Subject: Pottinger Wind Farm – Response to Further Requests for Additional Information – TfNSW and BCS

We refer to the Department of Planning, Housing and Infrastructure's (DPHI) request for additional information regarding the Pottinger Wind Farm (SSD-59235464), in response to further RFIs from:

Pottinger Wind Farm
Cobb Highway / Jerilderie Road
Strategic Design - CHL (Sight Distance)

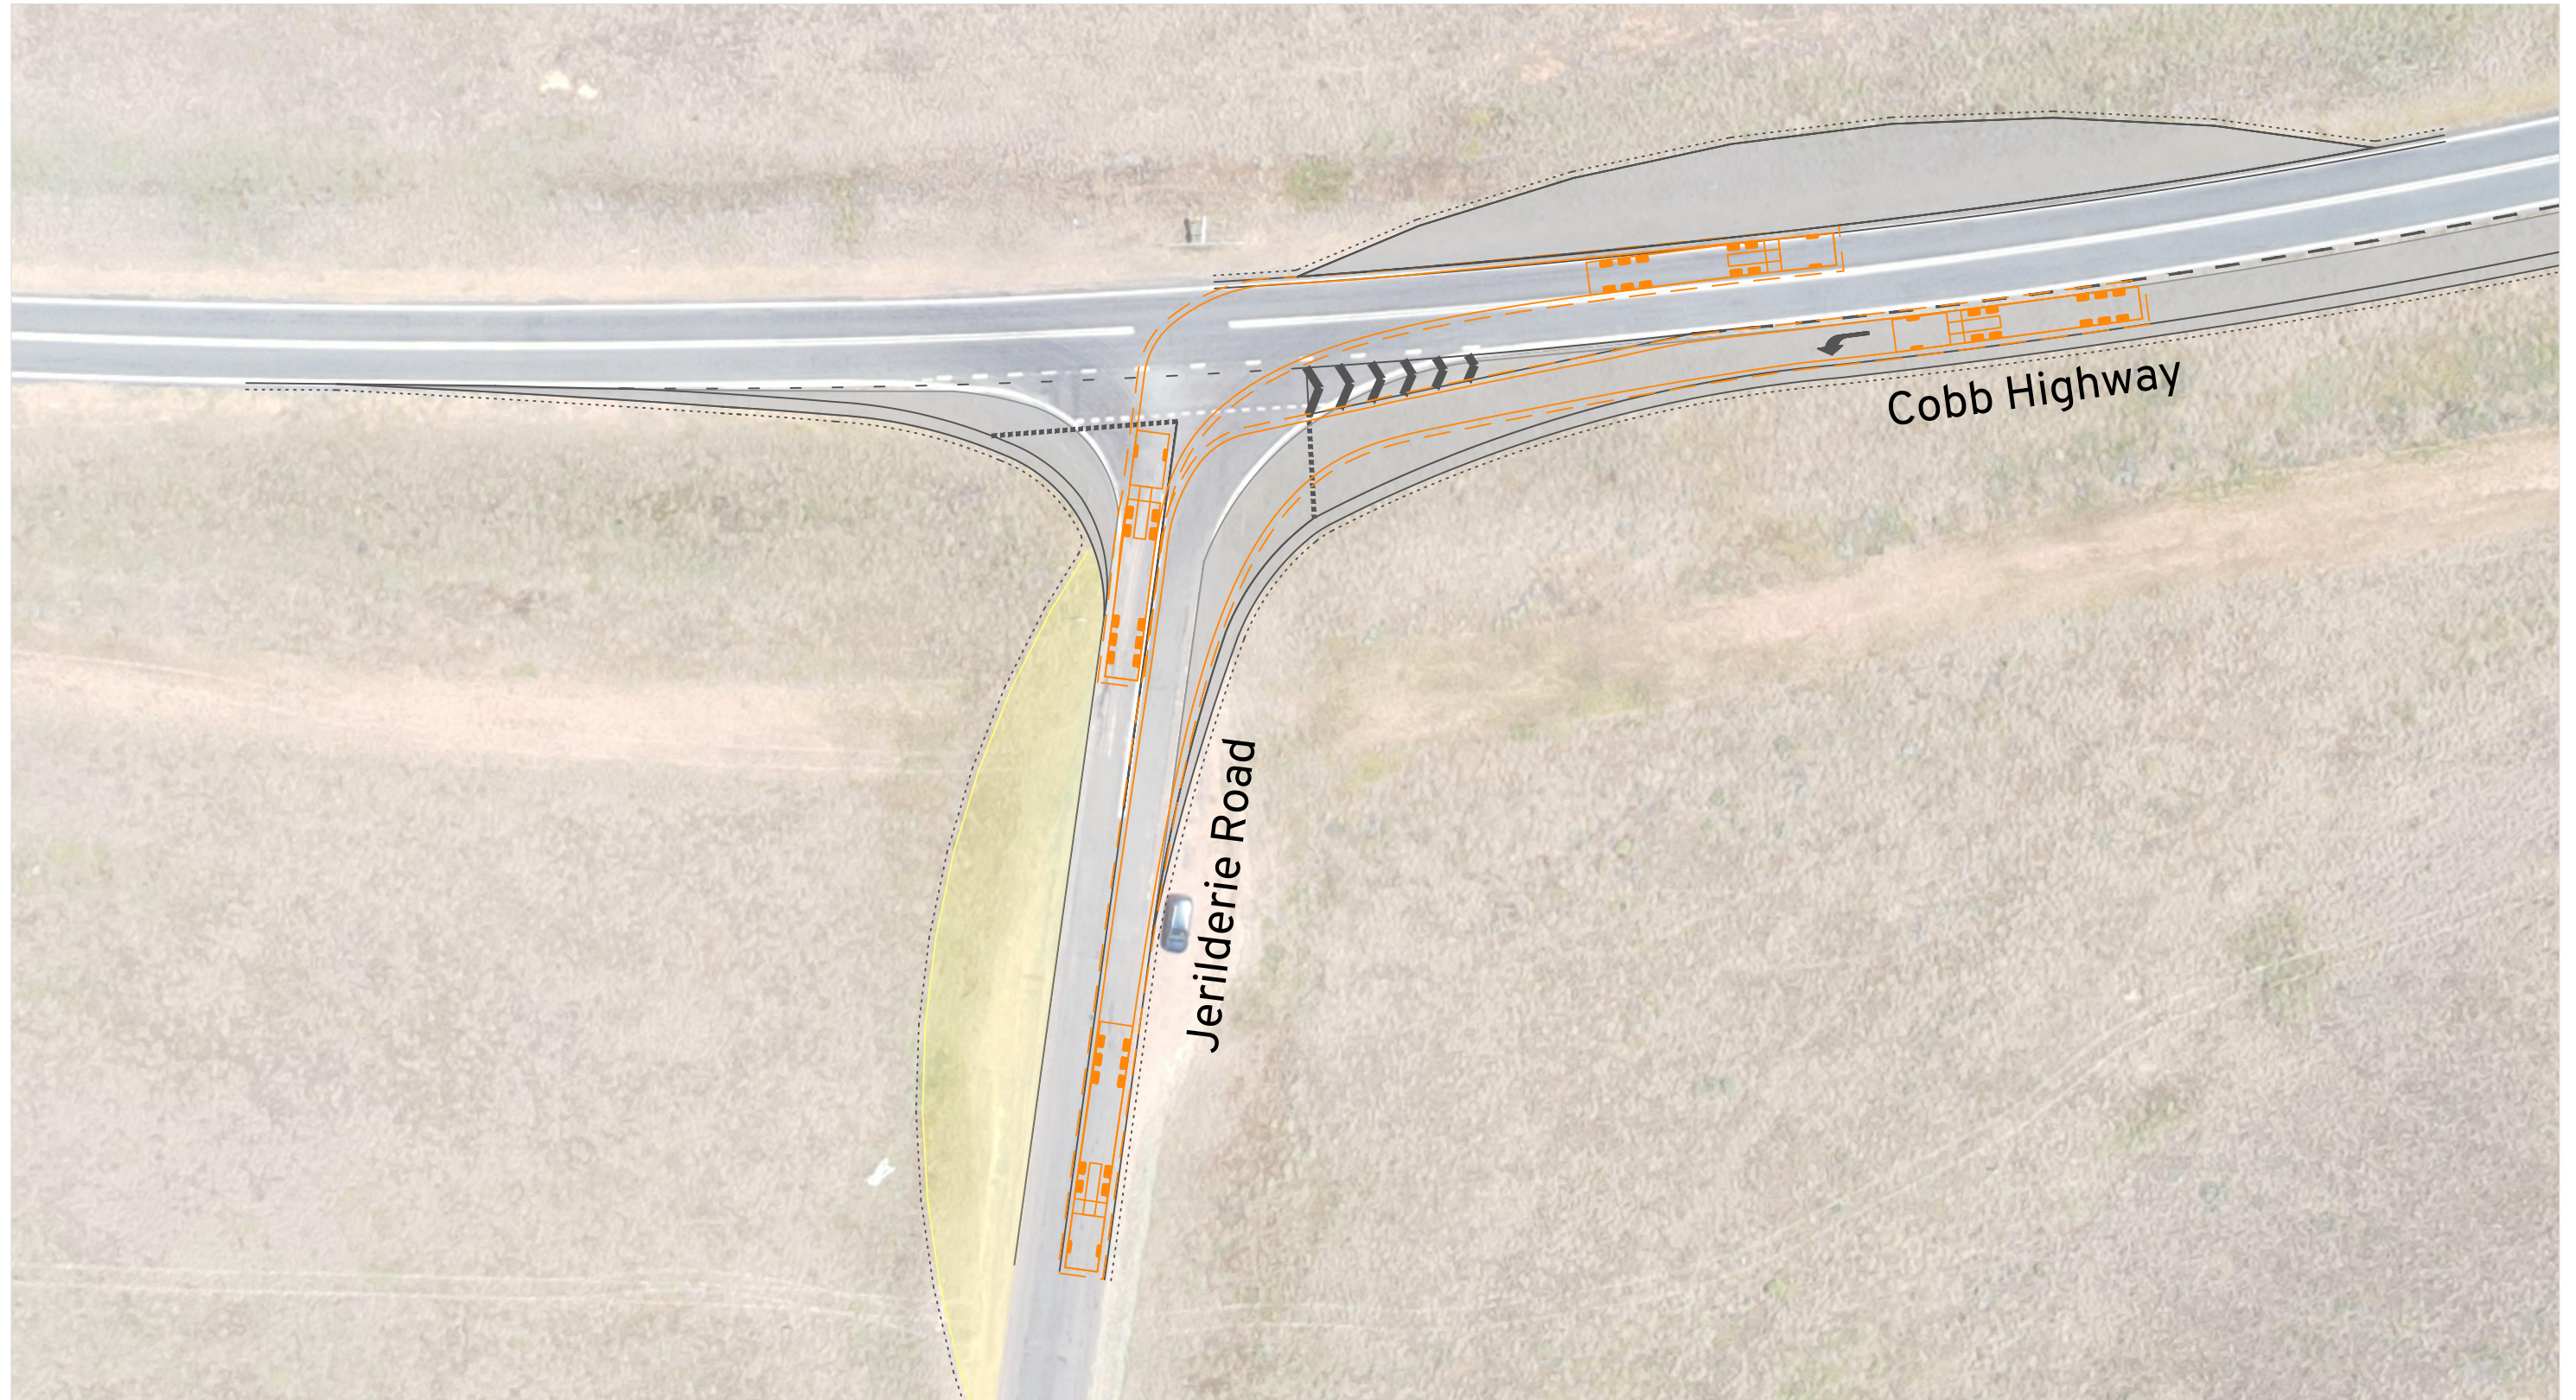
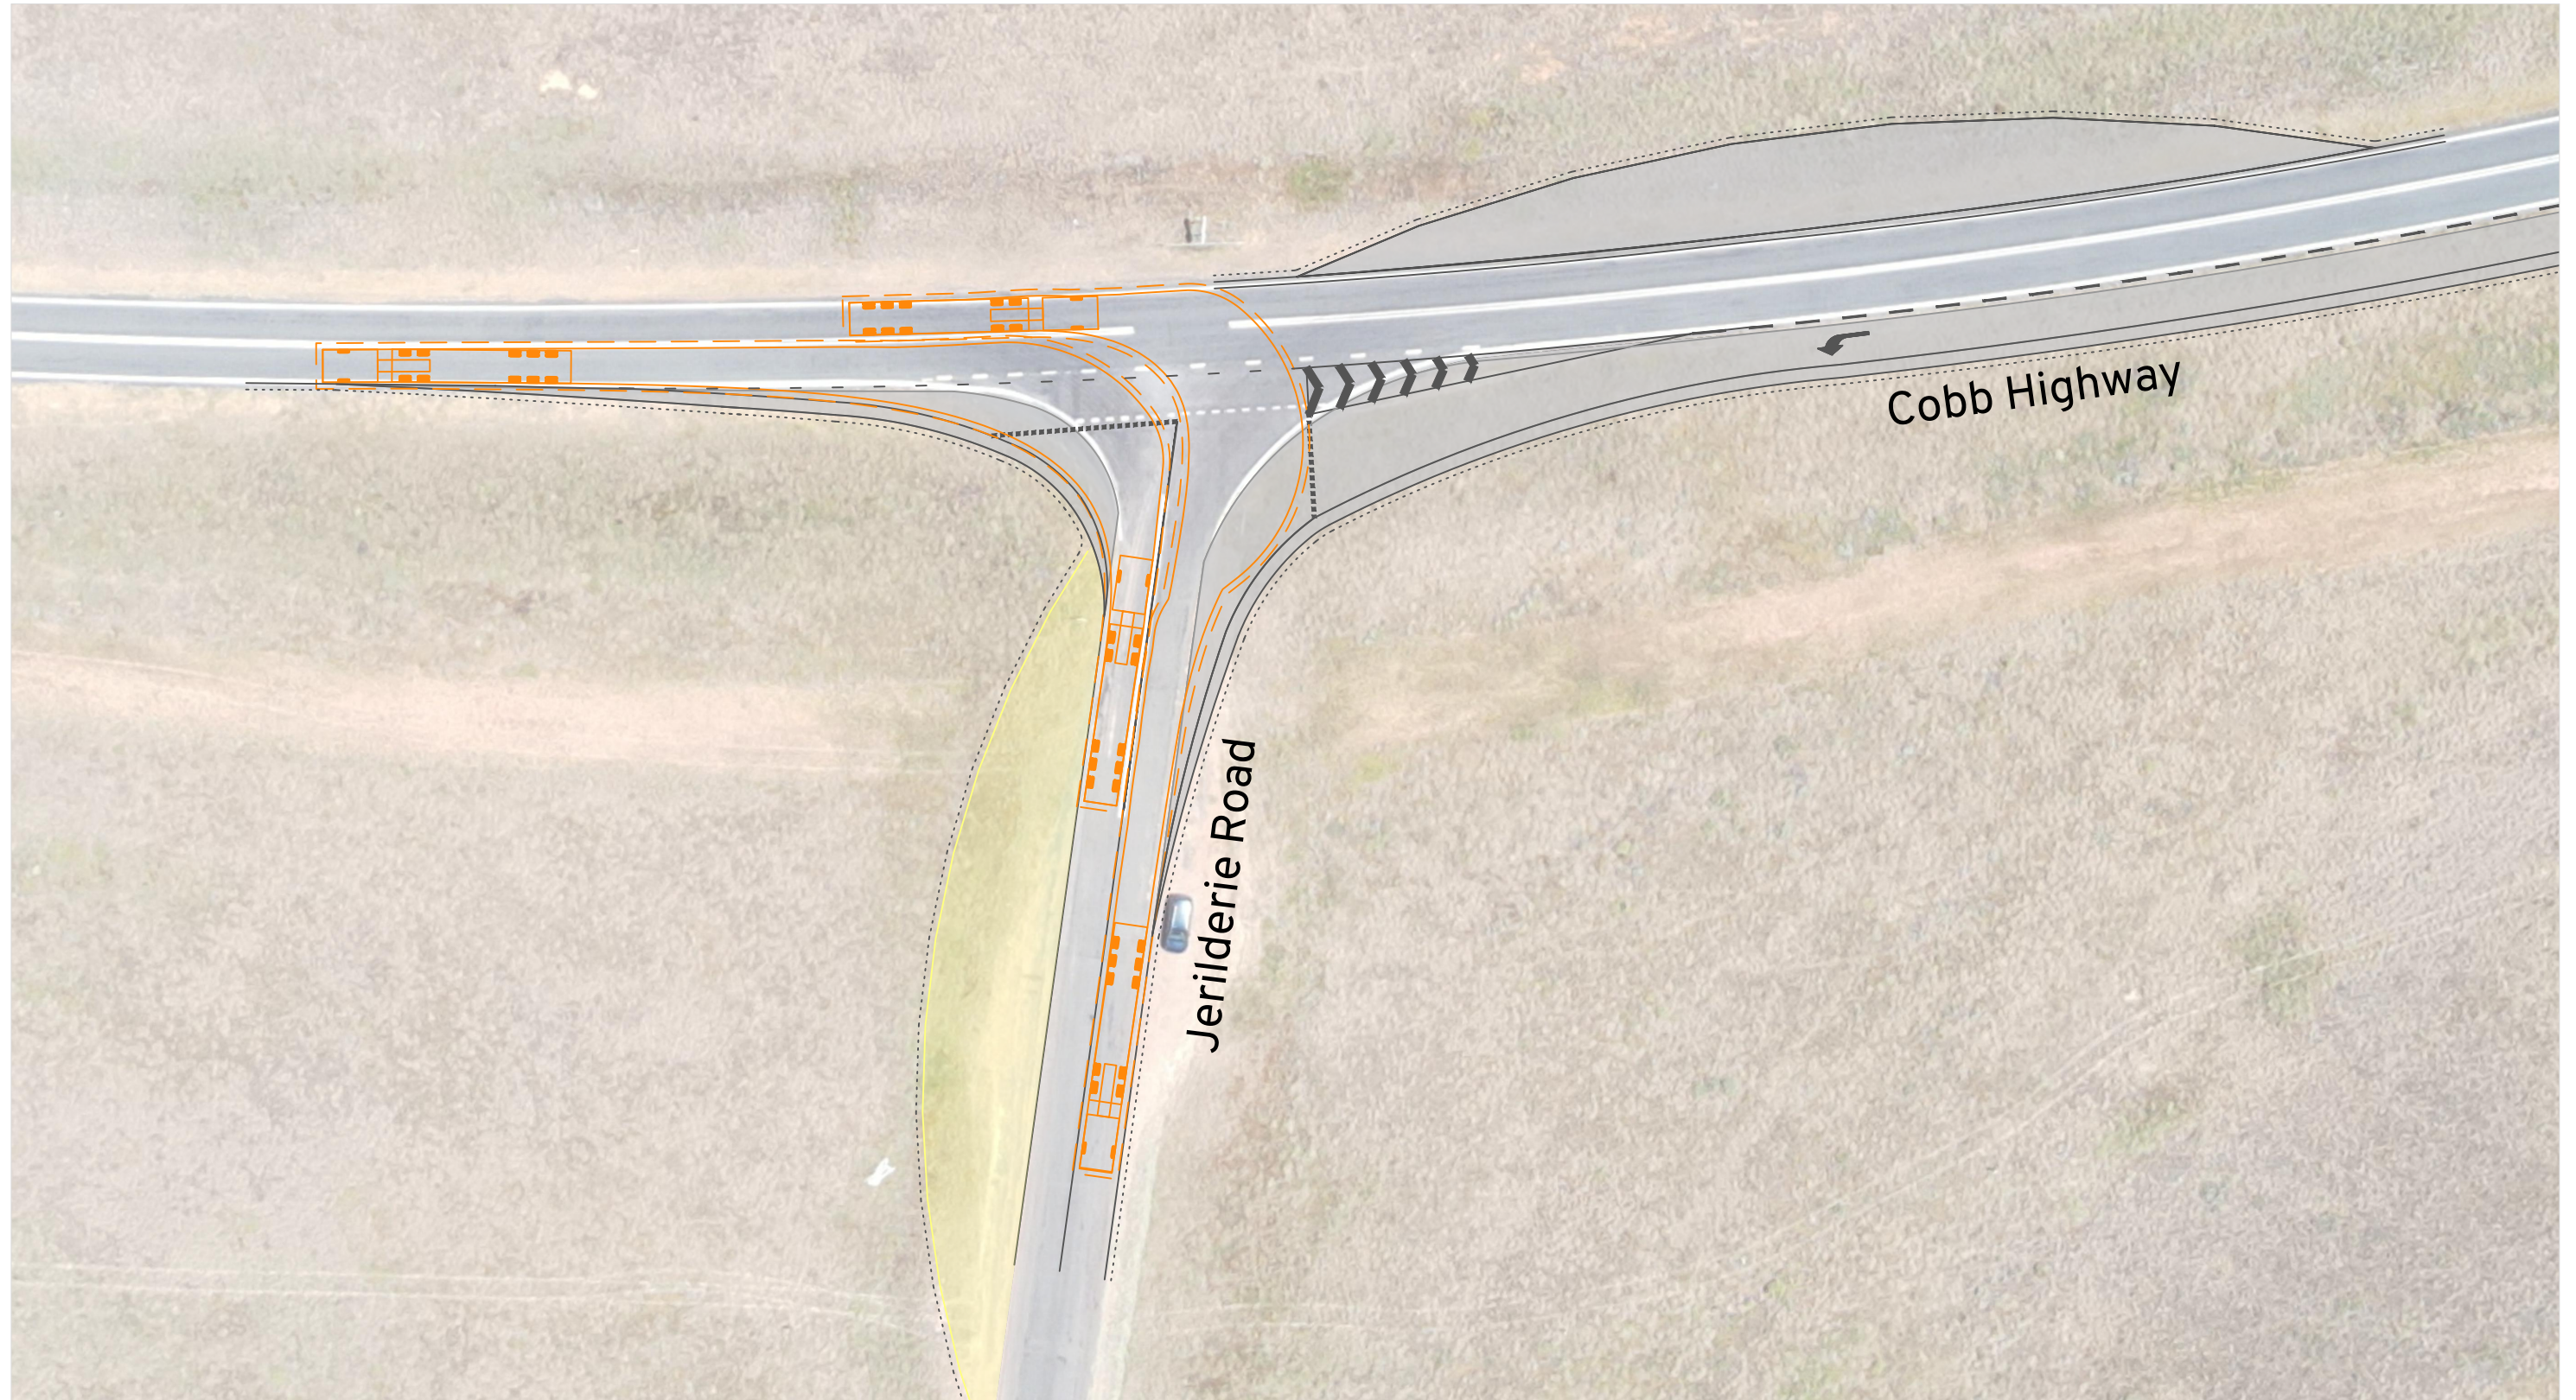
| Date | TfNSW request | Date | Response | Date | TfNSW Further Request | Date | Response |
|------------|---|------------|--|------------|---|------------|--|
| 16/01/2025 | Propose a method for the management of opposing traffic on the Cobb Highway and Barrier Highway (on sections where they have 3m wide travel lanes and no road shoulder), including during wet weather. If this method involves using pullover areas, the location and treatments of those pullover areas should be described. | 21/01/2025 | <p>Provided an indicative Traffic Management Method for Narrow Sections of Cobb and Barrier Highways, written by Amber (traffic expert).</p> <p><u>Please see Appendix E for final document.</u></p> | 24/01/2025 | Further requested a strategic design of a pull over bay including treatment type and design to be assessed / overlayed against the locations identified in the methodology to understand how it fits within the road corridor. | 30/01/2025 | <p>Provided a list of Cobb Hwy Temporary Pullover Bay Options</p> <p><u>Please see Appendix F</u></p> <p>Provided strategic design of a pullover bay.</p> <p><u>Please see Appendix G</u></p> |
